DEVELOPMENT REVIEW BOARD--SPEED MEMO

Development Review Board Comments

CITY OF ALBUQUERQUE
PLANNING DEPARTMENT
DEVELOPMENT REVIEW BOARD

Project #1001943
Application # 02DRB-00729
Lands of Julian C. Kelly

PLAT OF  
LOTS B-1 AND B-2  
LANDS OF JULIAN C. KELLY  
ALBUQUERQUE, BERNALILLO COUNTY, NEW MEXICO

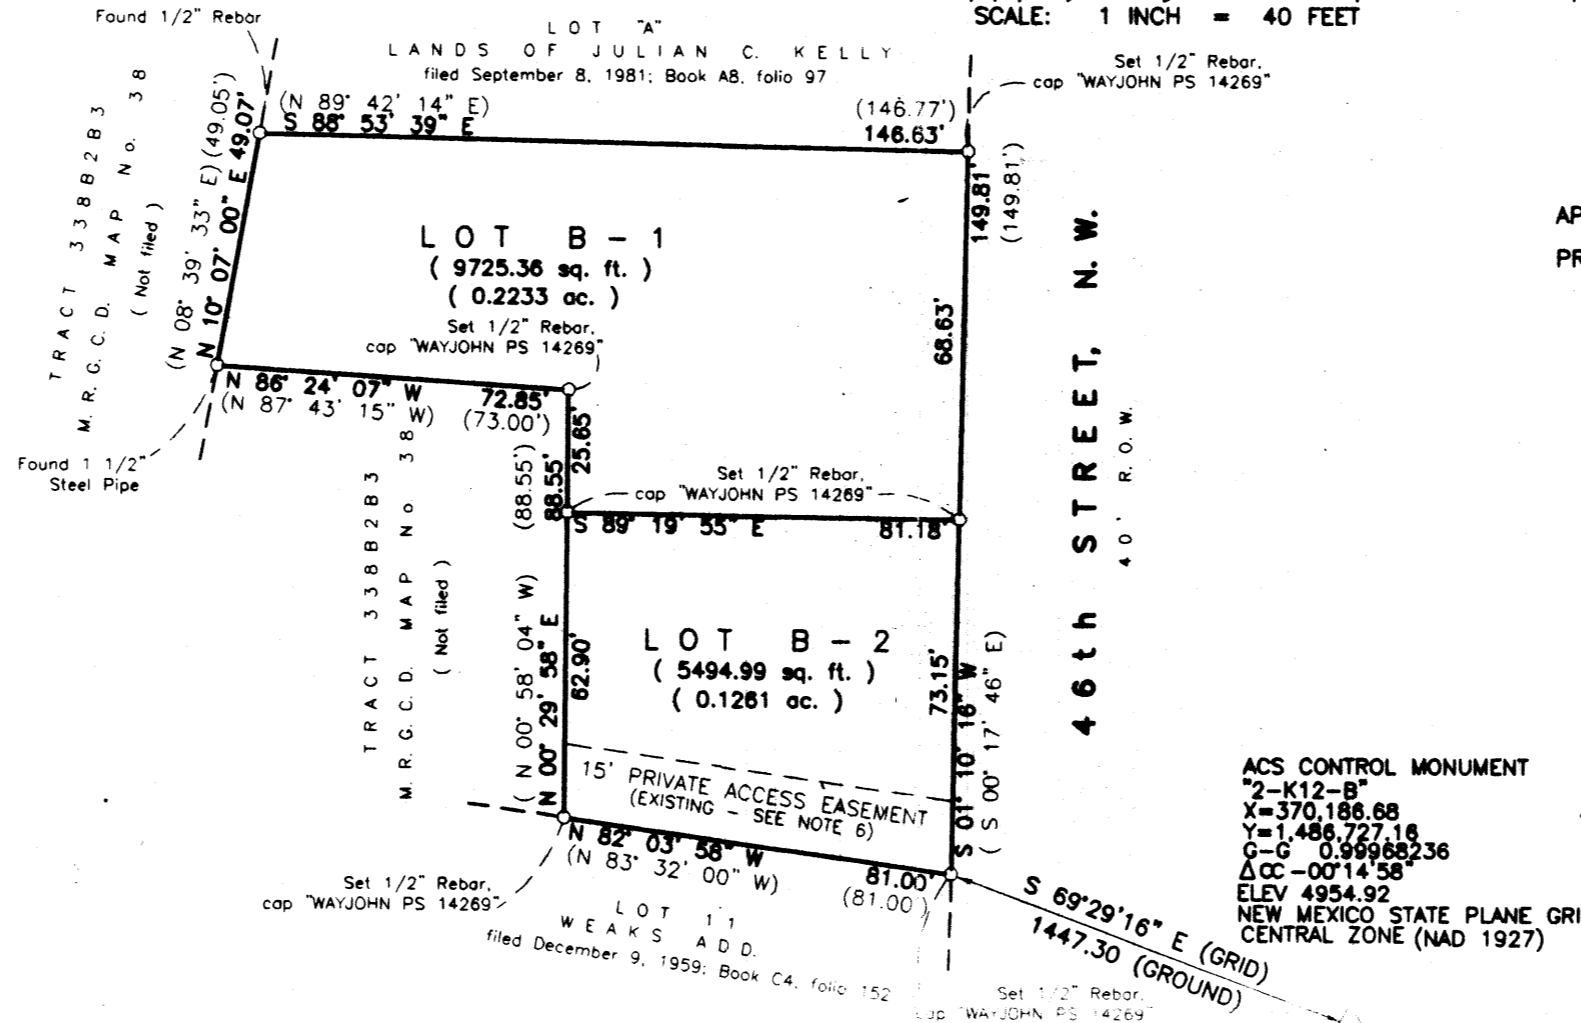
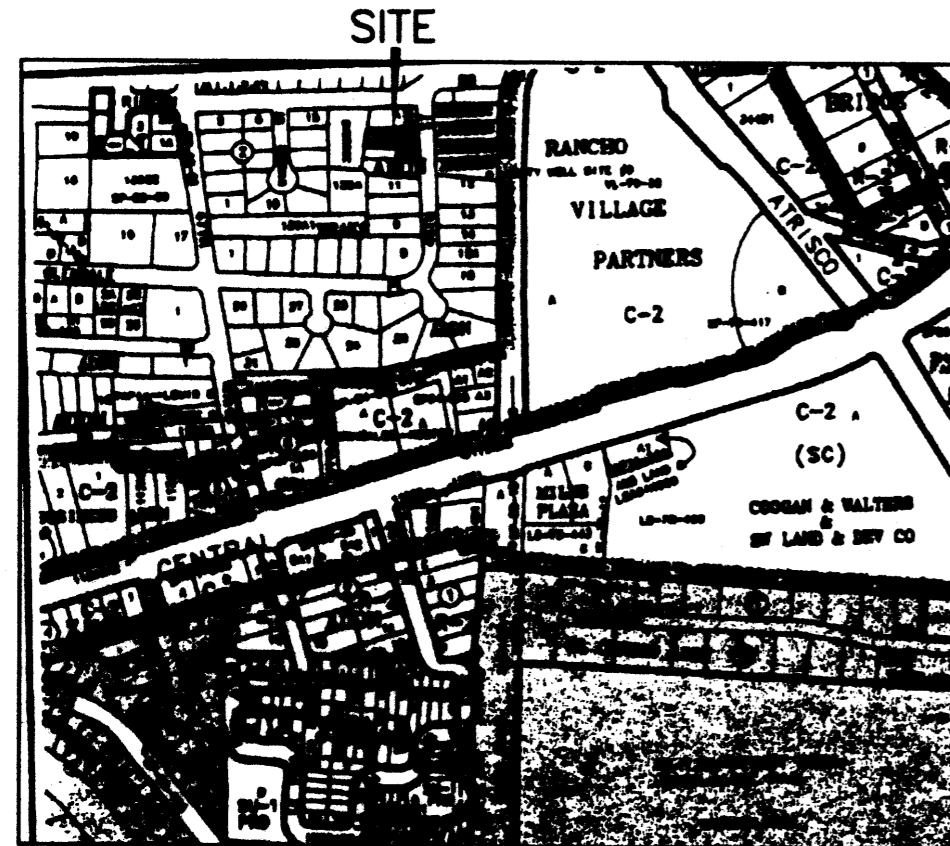
No.	Comment
<input type="checkbox"/>	Dedication of right-of-way to provided 9 feet from the face of curb to the property line is needed.

1. No objection to the proposed subdivision action given that setback requirements, lot area and width requirements are in compliance with R-1 zoning.
2. Include the Project # and Application # on the plat.
3. Planning signs last. All other City agencies and public utilities must sign off prior to requesting final signature by Planning.
4. Minor subdivision plats and those not completing vacation actions may be recorded at the County Clerk's Office by the applicant/agent. A copy of the recorded plat must be forwarded to Planning in order to close the case file.
5. Please provide a digital dxf file showing right-of-way, parcel and easement lines shown on the final plat, in New Mexico State Plane Feet, NAD 1983.

- TRANSPORTATION: _____
- UTILITIES: Public Edwck easement (approx 4ft in width) label 15' priv access also
- CITY ENGINEER / AMAFCA: _____
- PARKS / ~~CDP~~: CKL deposit slip & lot
- PLANNING (Last to sign): See comments

PN's w+ SAs;
correct I.D's of lots
to the west
